**From:** Paul Cann  
**Sent:** 29 September 2017 16:28  
**To:** Planning.Responses  
**Subject:** RE: Planning Consultation on: BE/113/17/RES

**APPLICATION**                      **BE/113/17/RES**

**Site Address:**                      Land West of New Barn Lane Bersted

**Description of Works:**                      Approval of reserved matters following outline consent  
BE/18/17/PL for appearance, landscaping, layout & scale for a  
mix of up to 90No. residential units, associated open space,  
landscaping, access & car parking

scheme: Land West of New Barn Lane, North Bersted
client: Linden Homes
drawing: Landscape Proposals
date: July 2017
scale: 1:200@A1
drawing no: LIN21257 IIC Sheet 2
drawn: LS checked: AE

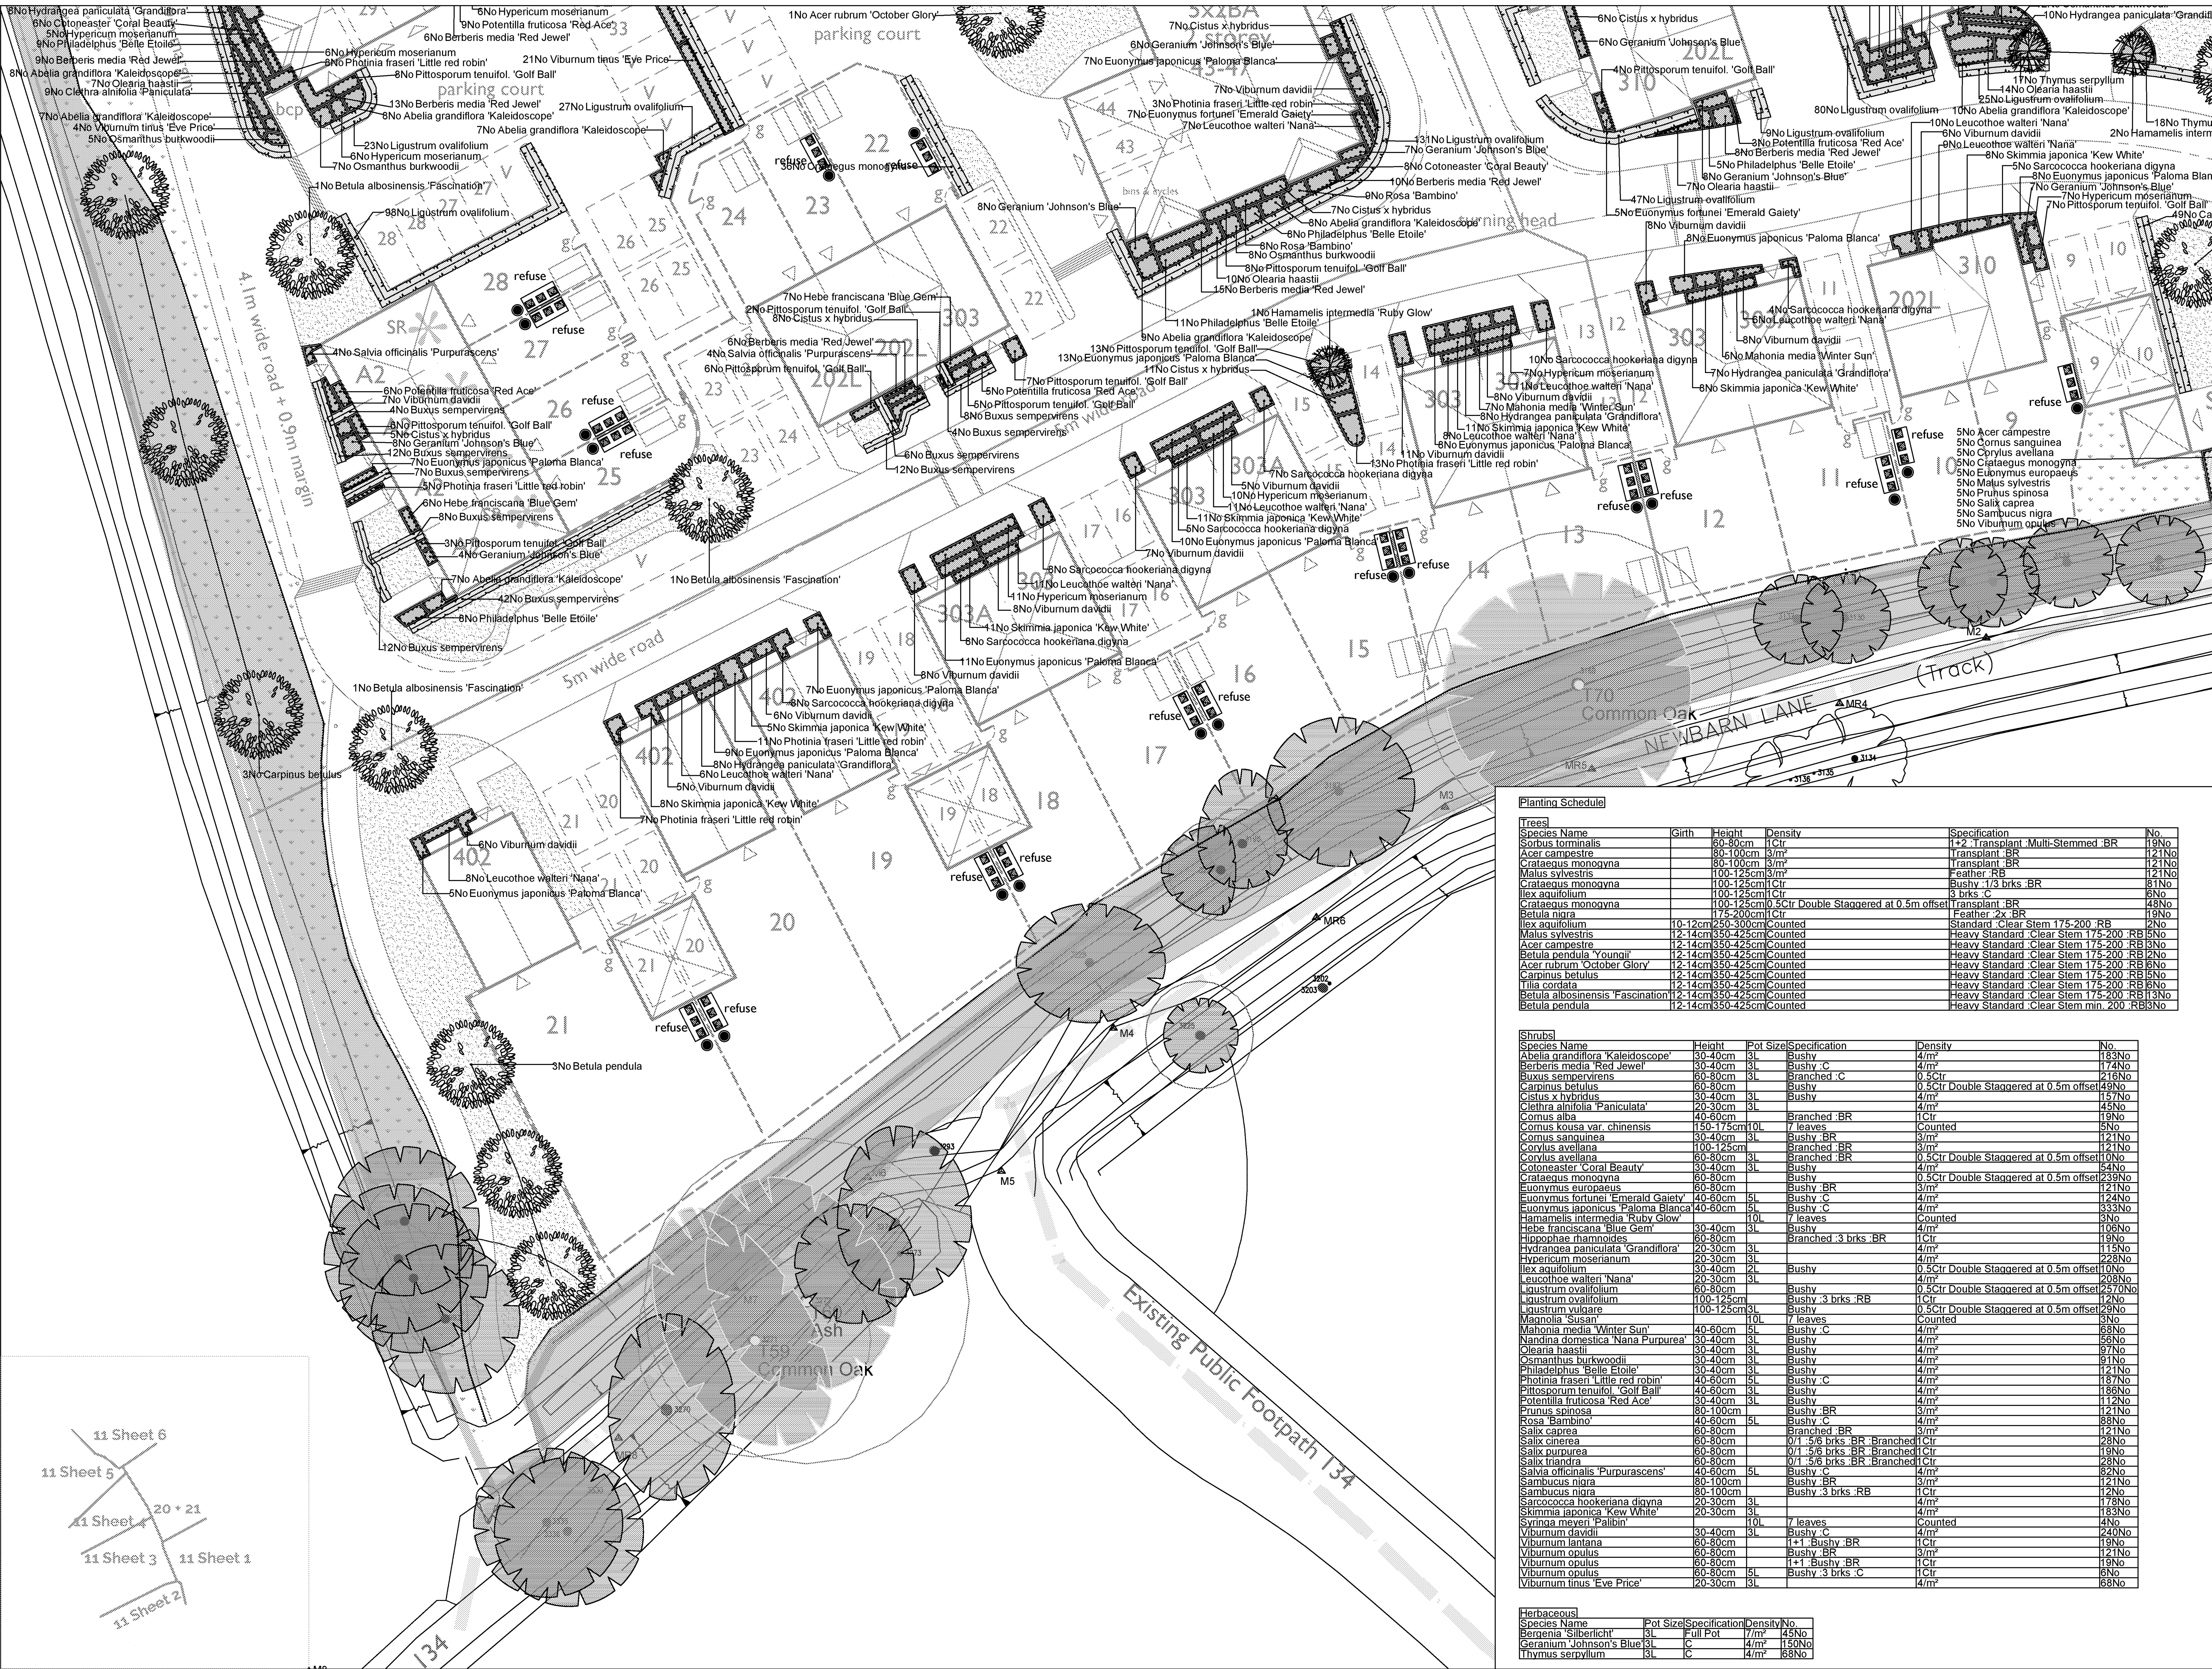
The detailed drainage design will be considered upon submission of a DOC application. It would appear that there is reasonable open space areas to accommodate storage structures/facilities but this is subject to approval of the detailed design.

In terms of the development layout and the provision of maintenance access to boundary ditches, predominantly on the northern, western and southern boundaries, the applicant should ensure that there is a minimum 3 metres from the top of the ditch bank to boundary fences, etc. The applicant should provide a dimensioned plan to confirm that this has been achieved along the entire length of the ditches. This aspect is also covered by a condition.
